PLANS RECVD 3.20.85

Old Town 7-11/Strip Center
Addison, Texas
Ben Pinnell

A1.1
OF SHEETS

01 SITE PLAN
1":10'-0"

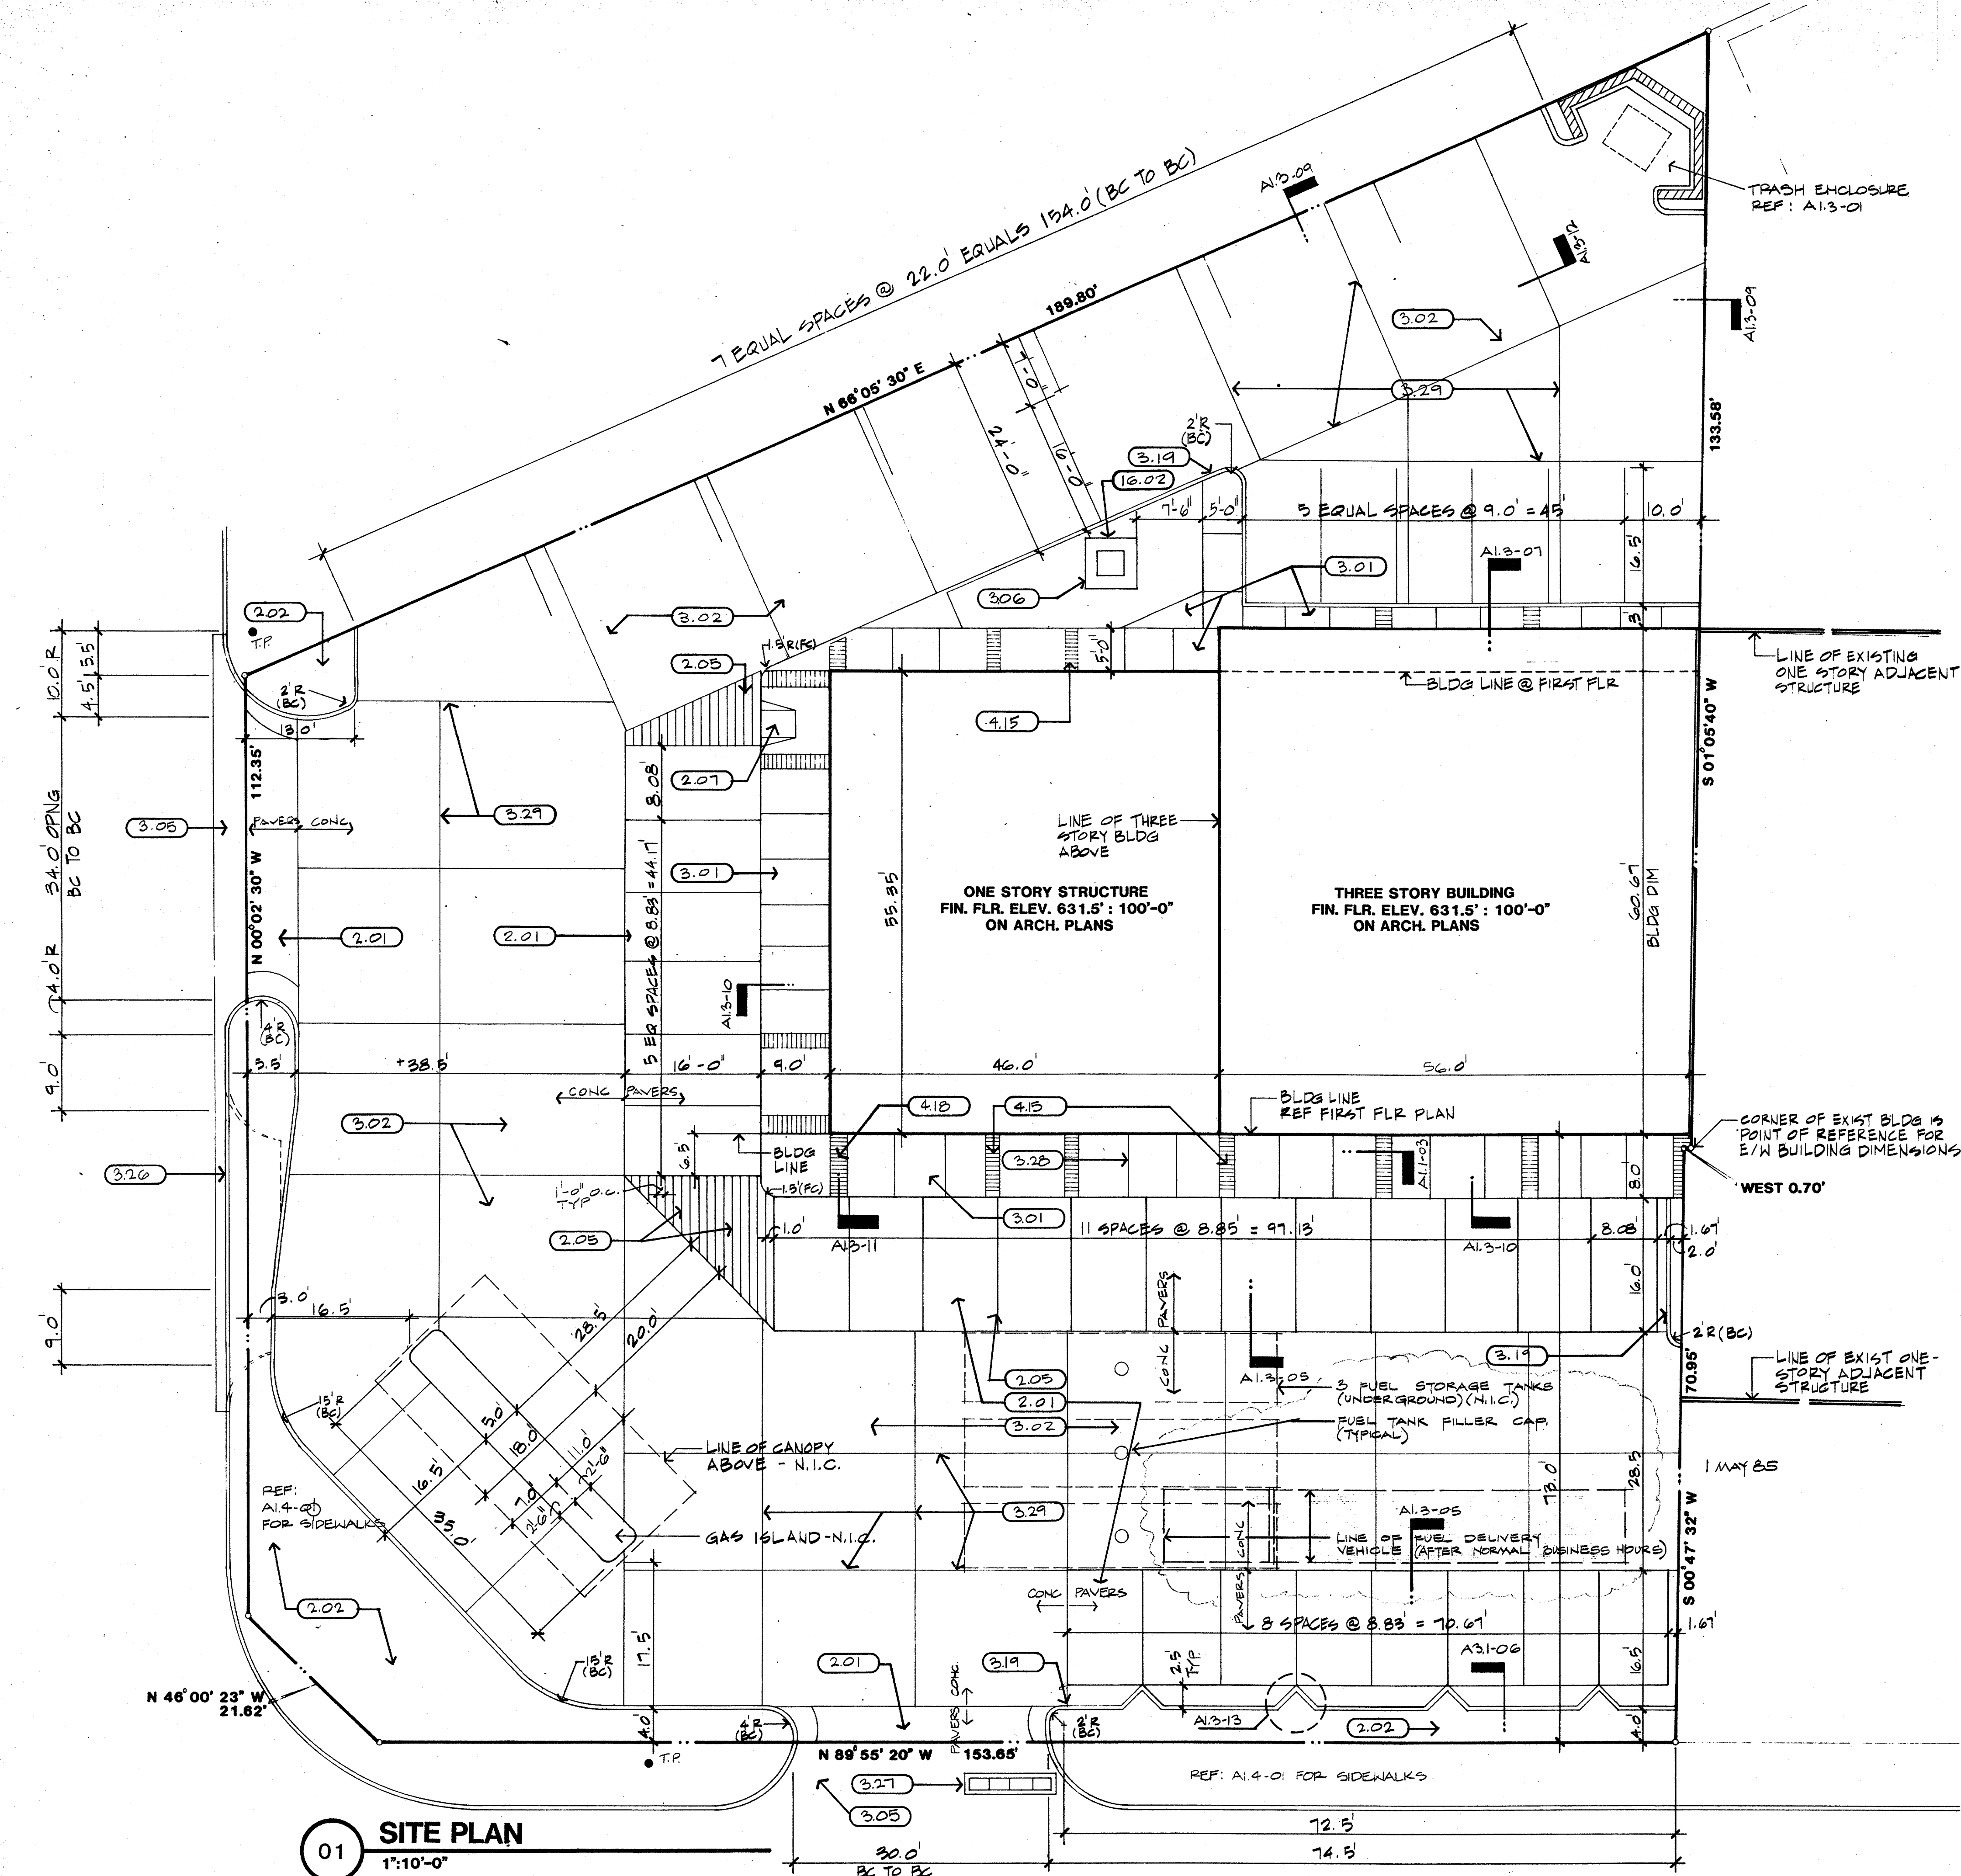
HOLD
1. SUBMIT F.A. HEIGHT APPROVAL.
2. STRUCTURAL PLANS MUST BE SEALED BY ENG.
WILL BE SUBMITTED @ LATER DATE PER JOHN BARRETT, E.O.I.

submit sprinkler plans... plans must be approved by STATE before C.O. issued

WHERE WILL UNDERGROUND GAS STORAGE TANKS BE LOCATED?
